Department for Transport

Date: 3 November 2020

Application by Highways England ("the Applicant") for an Order granting Development Consent to construct a replacement of three roundabouts on the A38 in Derby known as the Kingsway, Markeaton and Little Eaton junctions with grade-separated interchanges. ("the Proposed Development").

REQUEST FOR COMMENTS FROM THE APPLICANT, NETWORK RAIL, EAST MIDLANDS RESERVE FORCES AND CADETS ASSOCIATION, WESTERN POWER DISTRIBUTION, AND OTHER INTERESTED PARTIES

Drawing Number	Originator	Volume	Rev
HE514503 -ACM -DCO			C02
A38_SW_PR_ZZ	-DR-DC-9702		
Location	Type	Role	Number

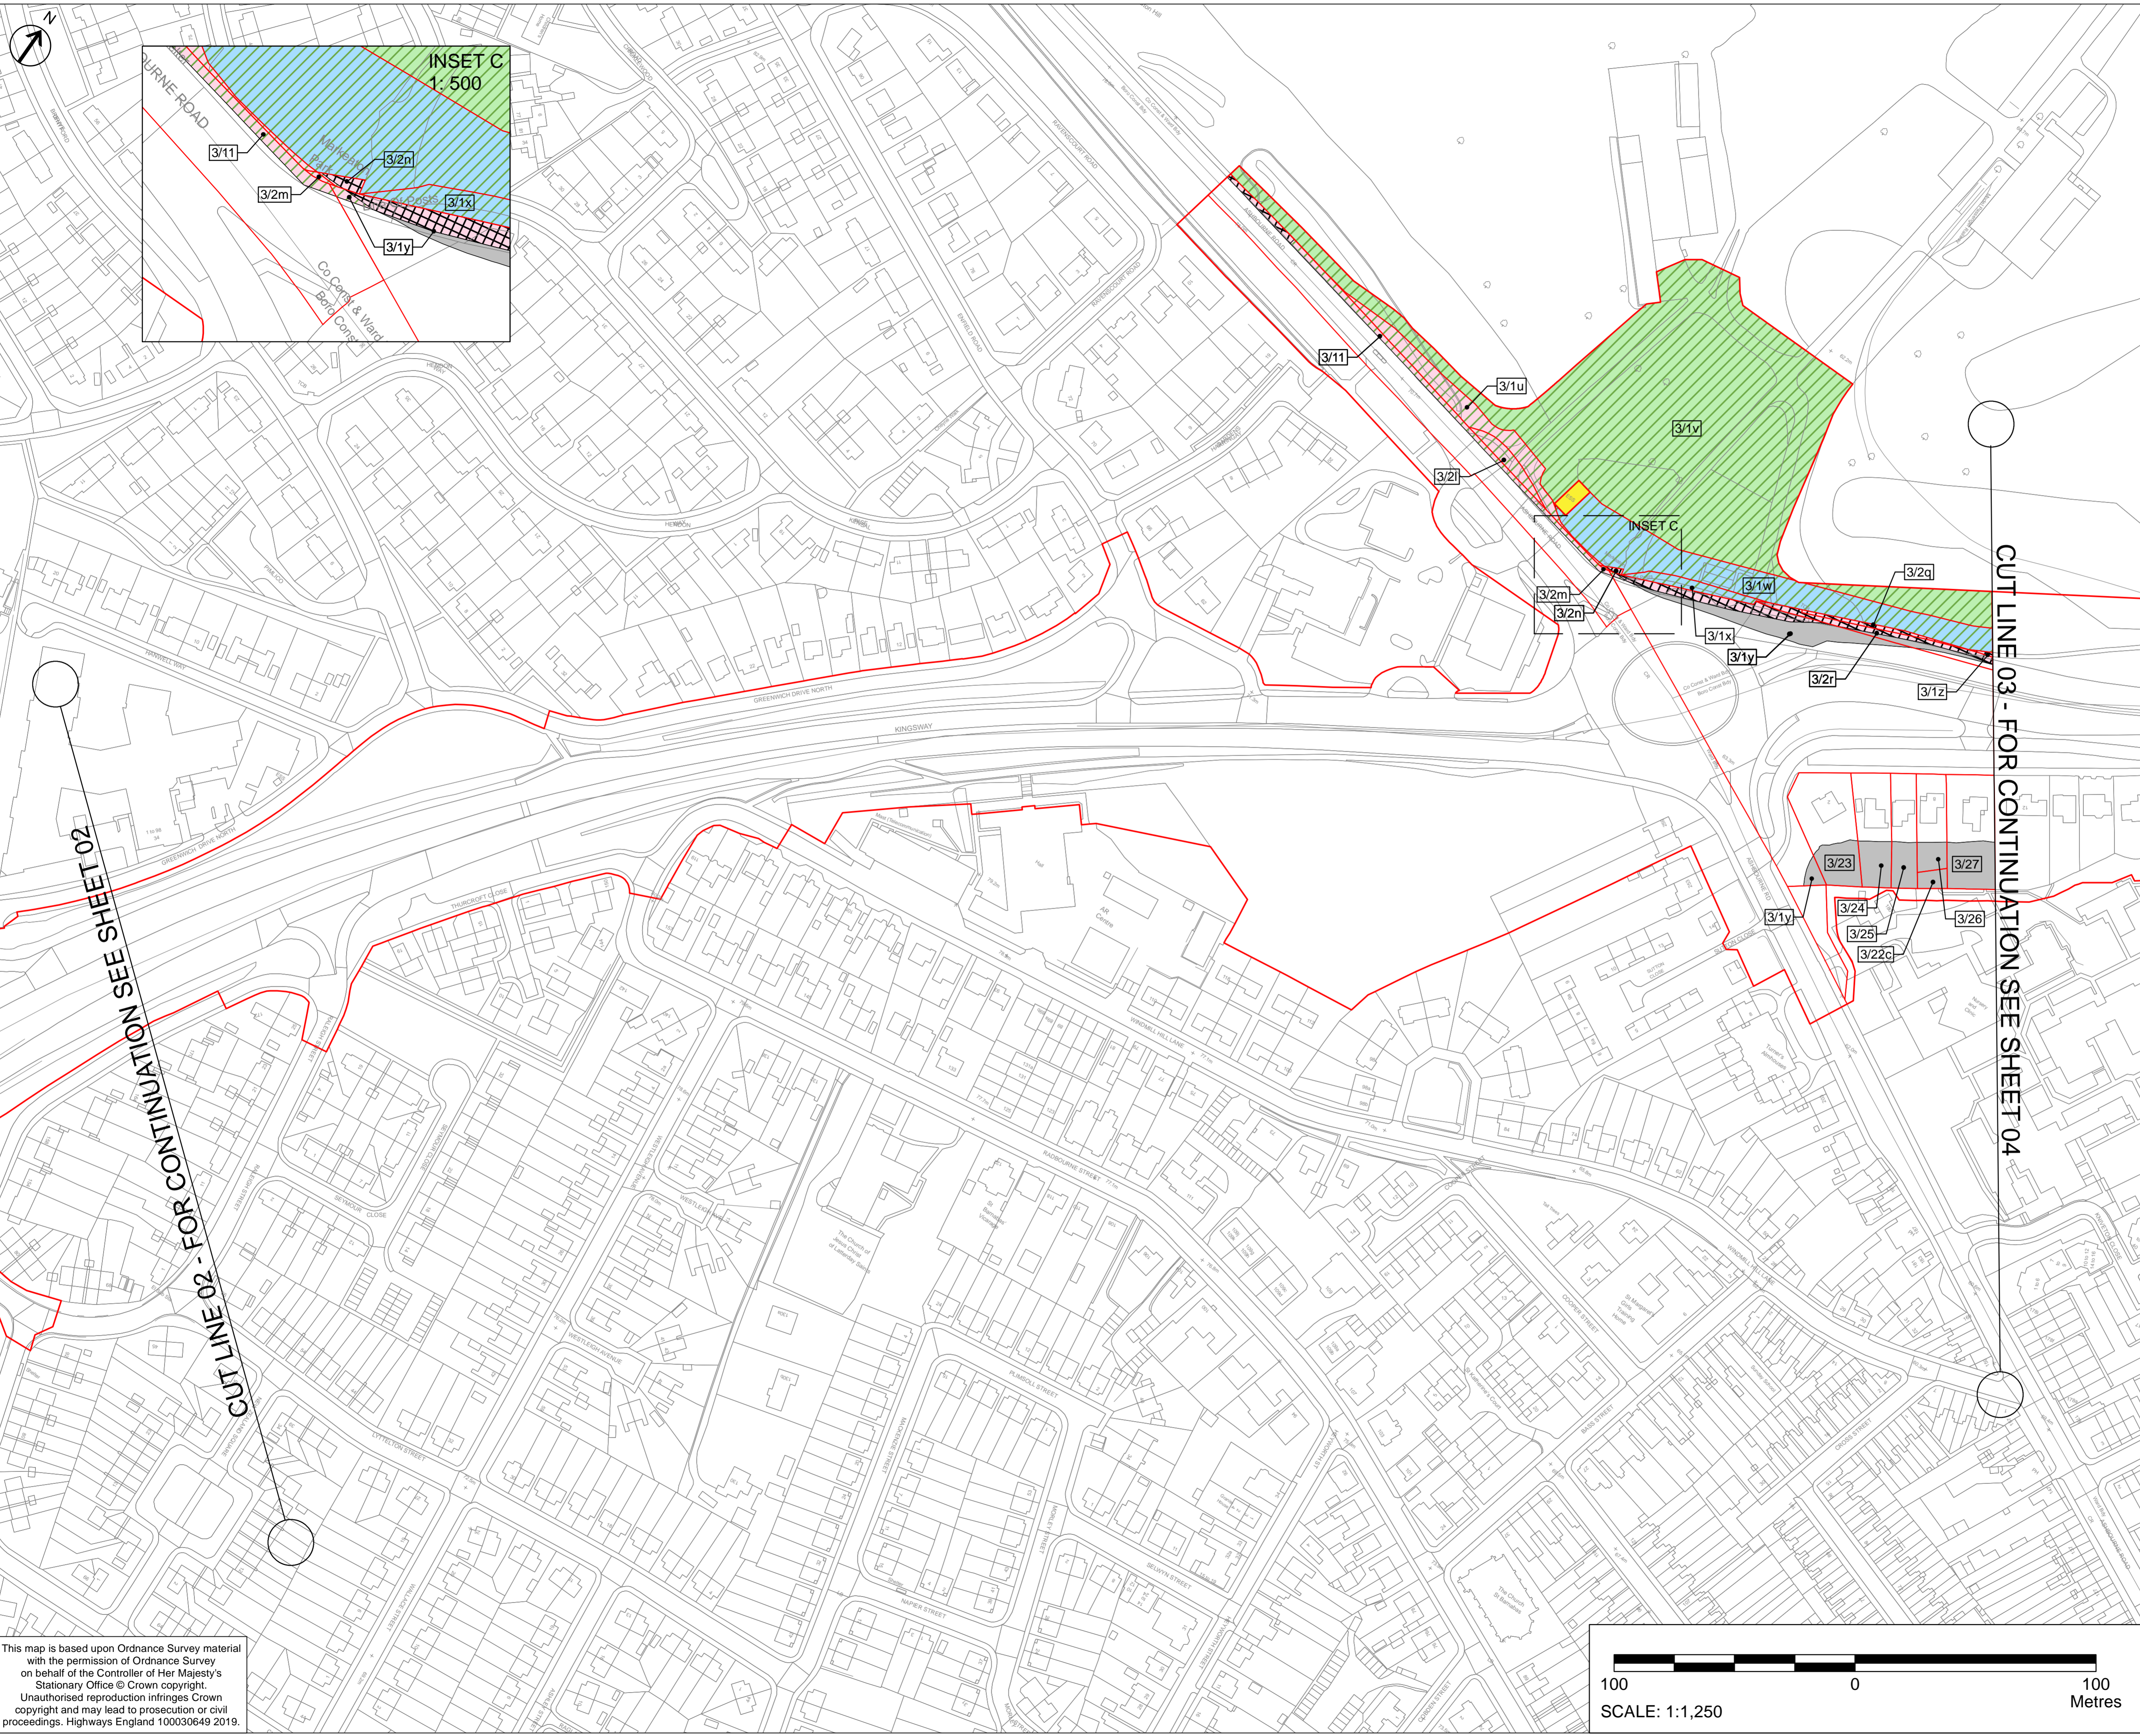
Plot 2/9 is not included in Part 5 (special category land) of the book of reference but is included in the definition of "the special category (rights) land" in article 38(5) of the DCO and is shown as being special category land on the special category land plans. The Applicant is asked to clarify whether plot 2/9 has been correctly defined as special category (rights) land notwithstanding its omission from Part 5 of the book of reference.
